Marine Management Organisation

MMO Reference: DCO/2021/00002
Planning Inspectorate Reference: EN010119
Identification Number: 20051047

24 June 2025

Planning Act 2008, Proposed North Falls Offshore Wind Farm Project Order Deadline 6 Submission

## **Appendix B. Plots for Comparable Hammer Strike Energies**

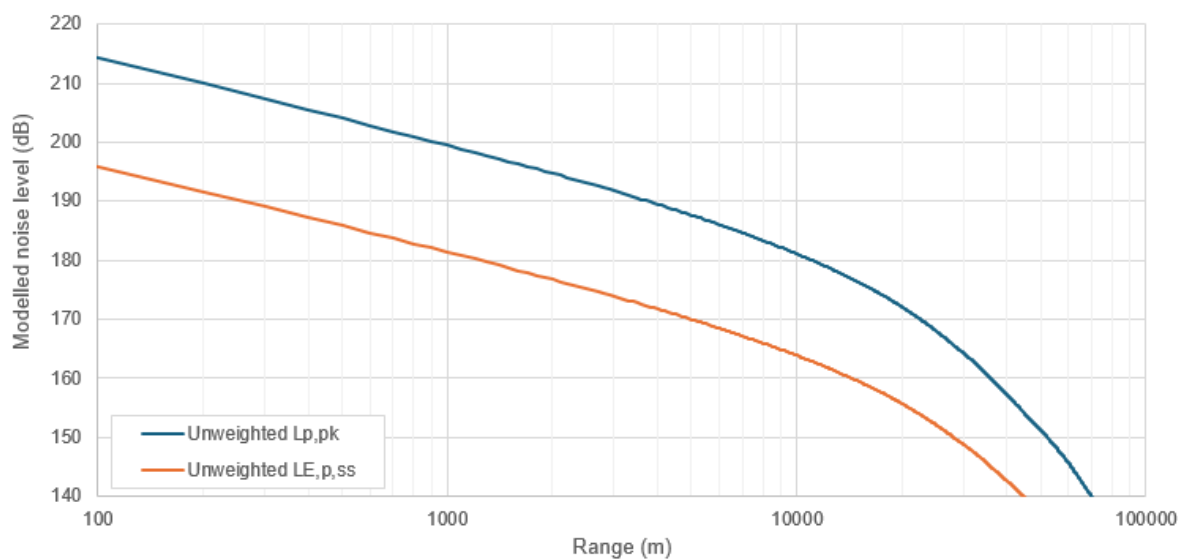
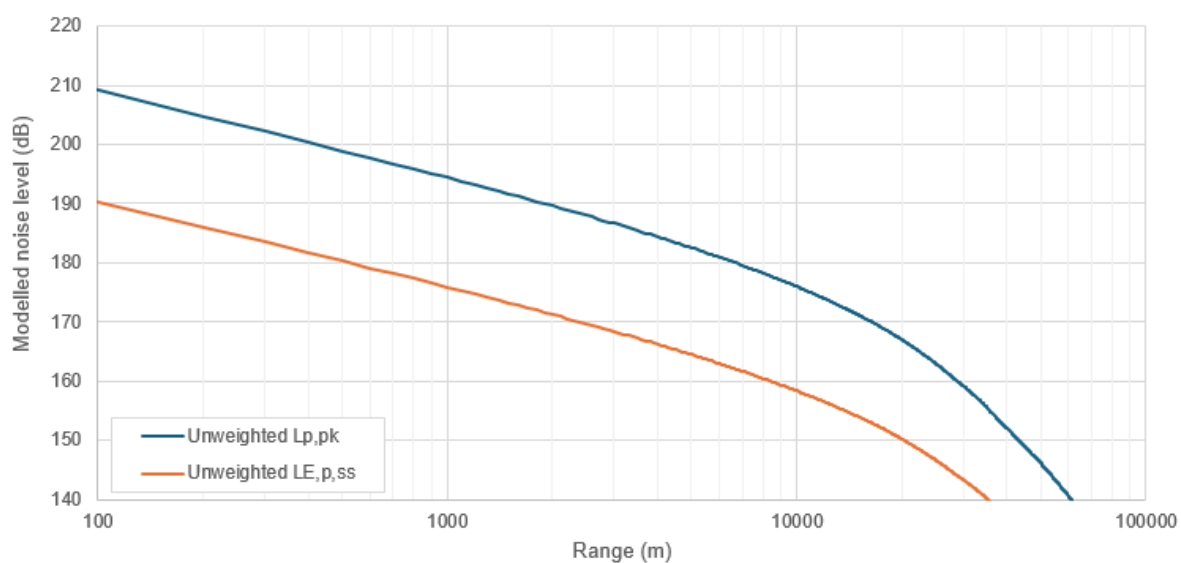
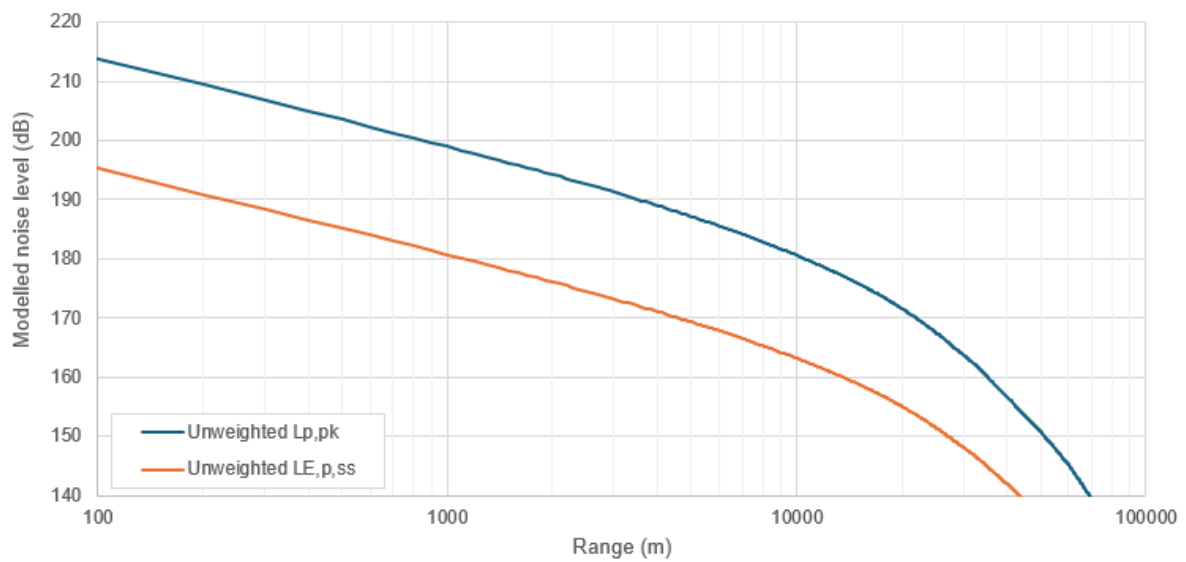
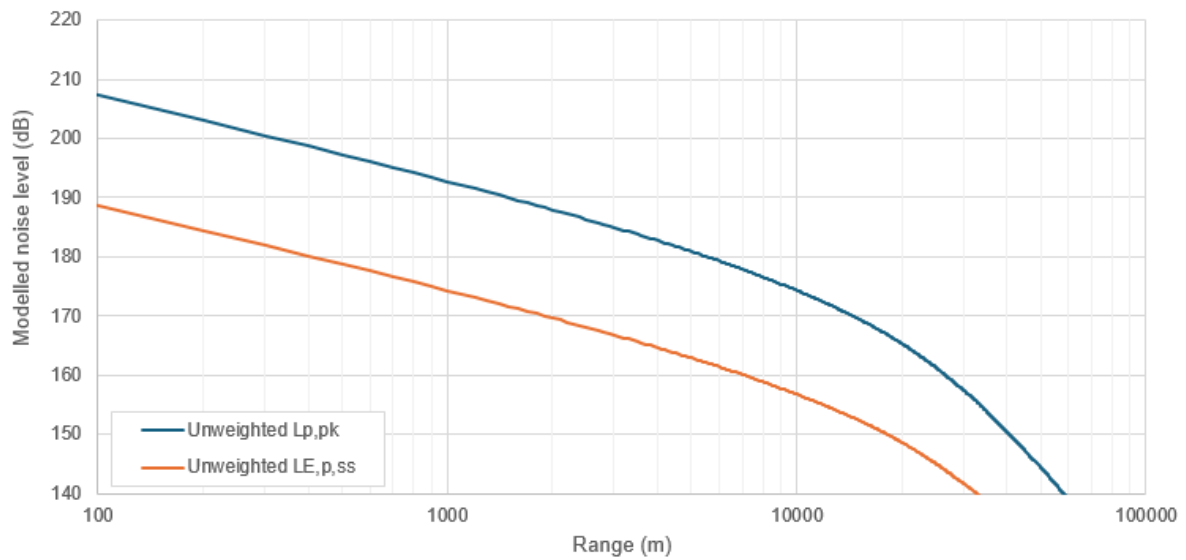
4.4.3 The MMO is content with the plots for Comparable Hammer Strike Energies provided in Appendix B.
